Our Case Number: ABP-314724-22

Re: Railway (Metrolink - Estuary to Charlemont via Dublin Airport) Order [2022]
Metrolink. Estuary through Swords, Dublin Airport, Ballymun, Glasnevin and City Centre to Charlemont,
Co. Dublin

Re: Railway (Metrolink–Estuary to Charlemont via Dublin Airport) Order 2022

District 7 Community Alliance - Submission on MetroLink

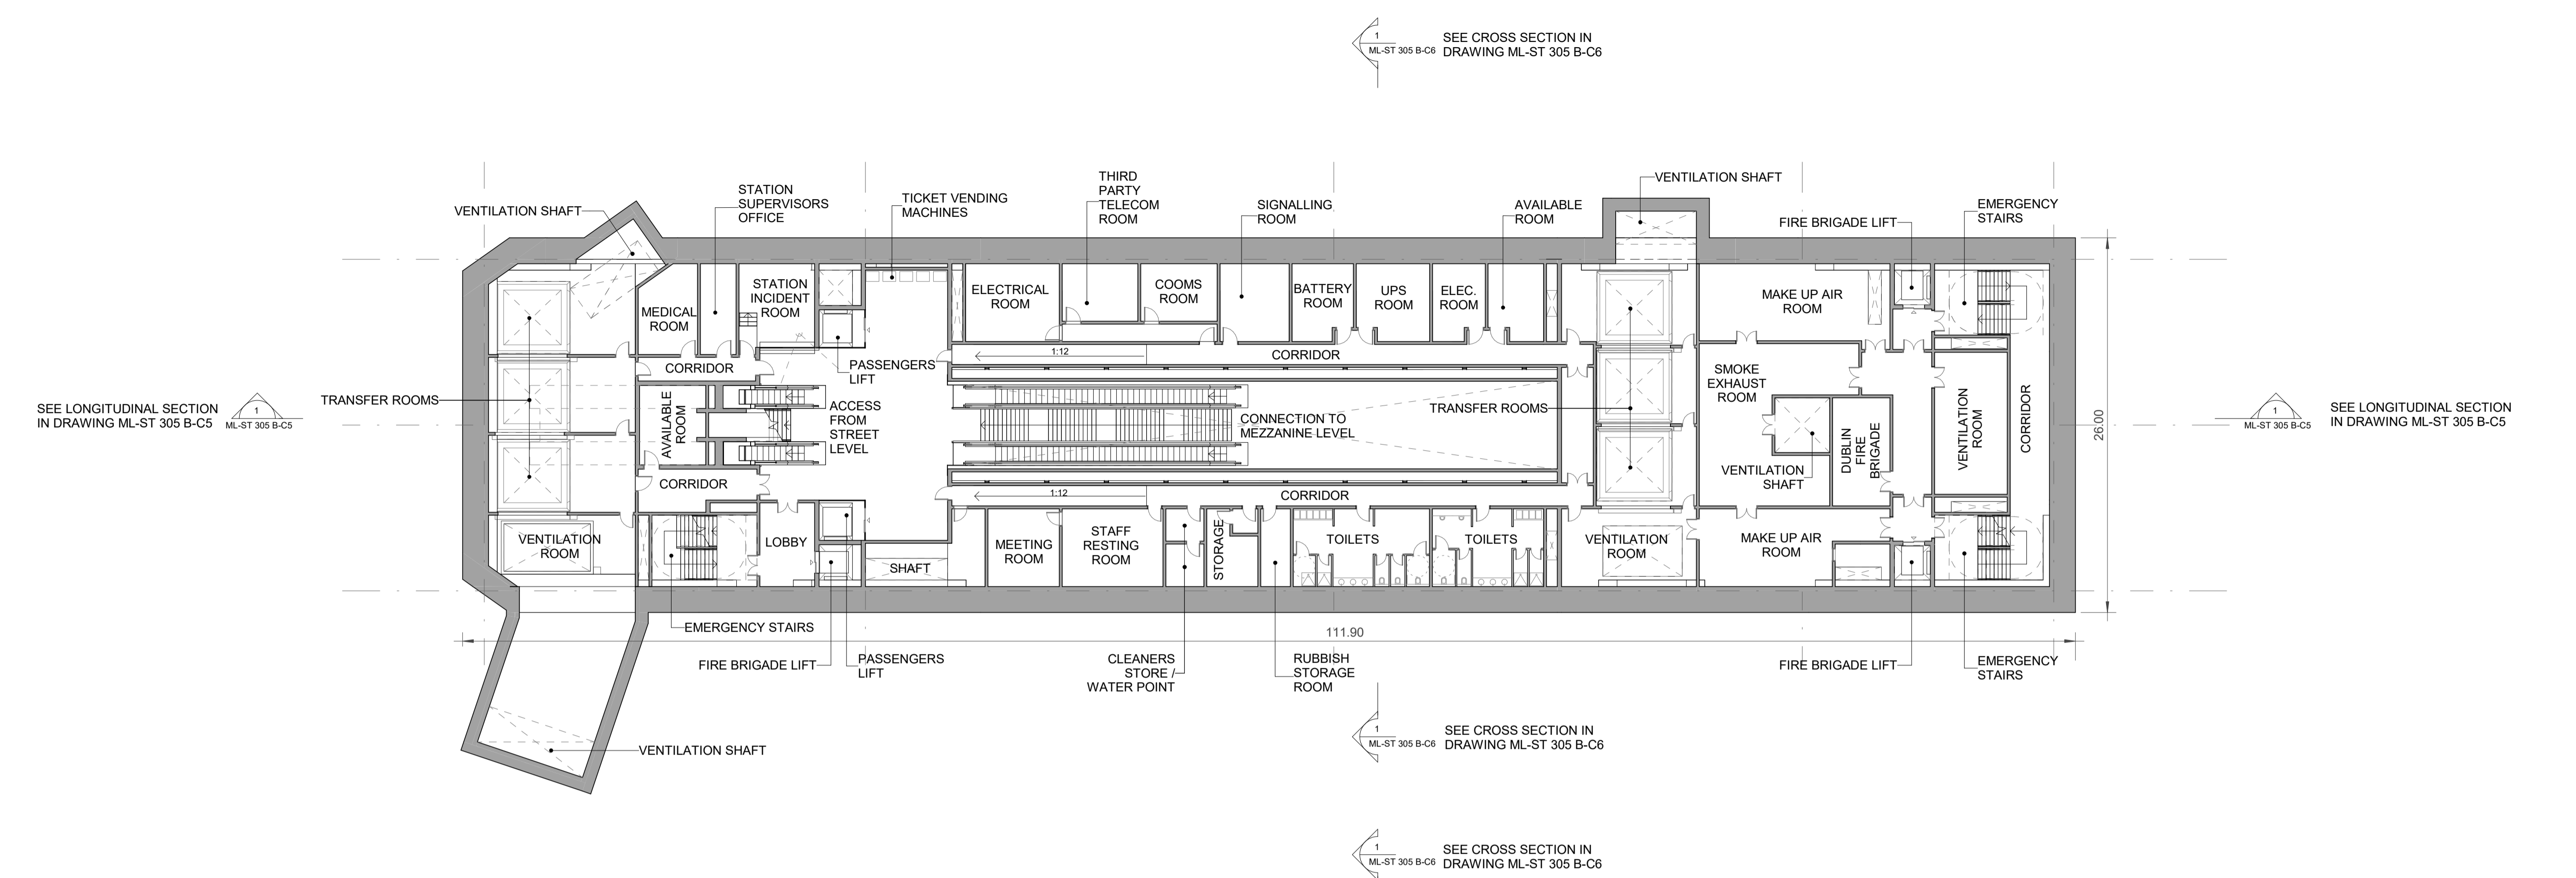
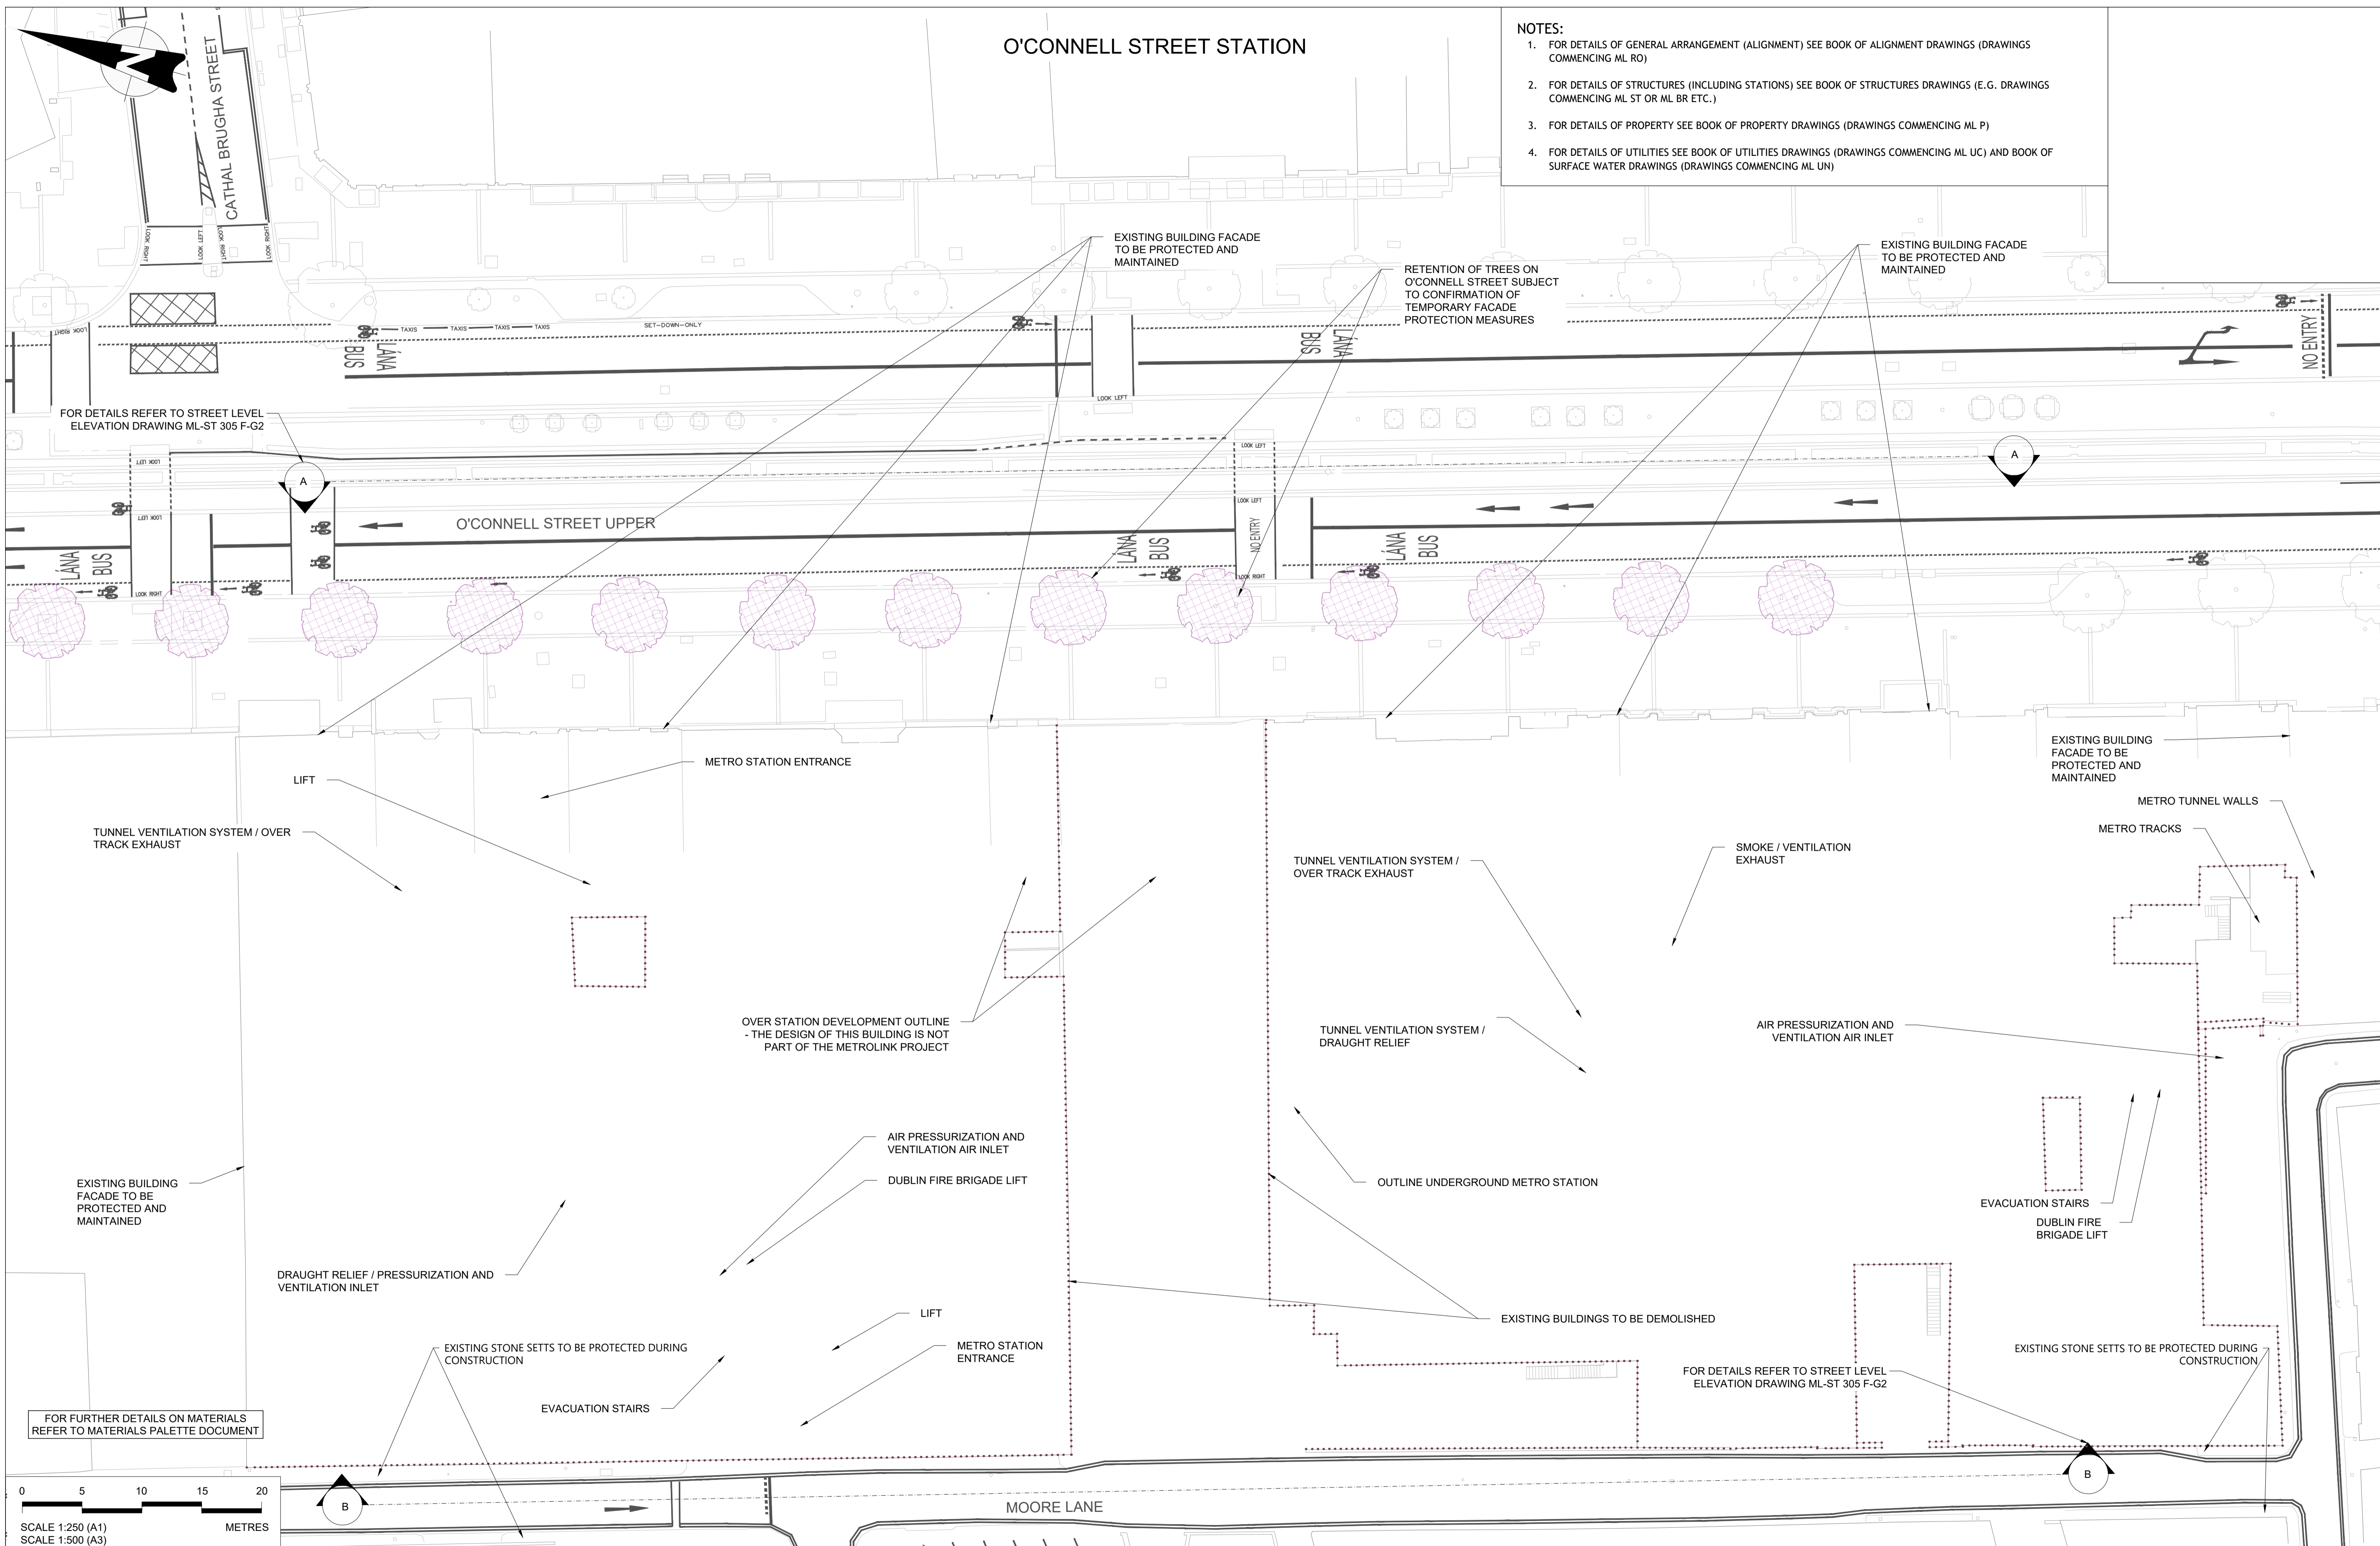
It is our view that the station design, particularly its prominence and elevation, and construction materials, is out of character with the surrounding architecture, and not in keeping with this Objective.

- Voluminous design and obtrusive orientation of the station;
- Excessive use of bollards;
- Excessive hard landscaping and construction of a ‘plaza’;
- Construction materials and colour scheme of the station and ancillary buildings are inappropriate and do not enhance the architectural quality of the streetscape;

- The proposed single access to the station (these could be moved south to provide dual access to/from Eccles Street and Berkeley Road to/from the proposed station box from the south. The access canopies could then be located within the area currently finished in tarmac adjacent to St Joseph’s church thus avoiding unnecessary intrusion in the Four Masters Park. This would allow for the retention of much of the historic railings as well as restoration of the Four Masters cross to its original location);

- Proposed location of ventilation shafts, lifts and other structures (e.g. skylights) along Berkeley Road (which could also be moved to a

location similar to that noted above in relation to access points), and their design and materiality which is not in keeping with the visual heritage of the existing buildings;

- The proposed relocation of the Four Masters Cross is inappropriate and consideration should be given to its reinstatement to its original location as noted above.

- 1) A station design that is more visually appropriate for a metro station in a very small urban small park surrounded by Victorian buildings;
- 2) Relocating the station access points south to a location adjacent to St Joseph's church (already part of the proposed CPO for the project) and providing dual access onto Eccles Street and Berkley Road perpendicular at ground level to the station box underground so it is less disruptive and allows for full reinstatement of the Four Masters Park;

- 3) Also removing the unnecessary 'light wells' as the use of artificial light in all areas underground will be unavoidable even during day time hours in order to comply with accessibility and health and safety requirements for the operation of MetroLink;
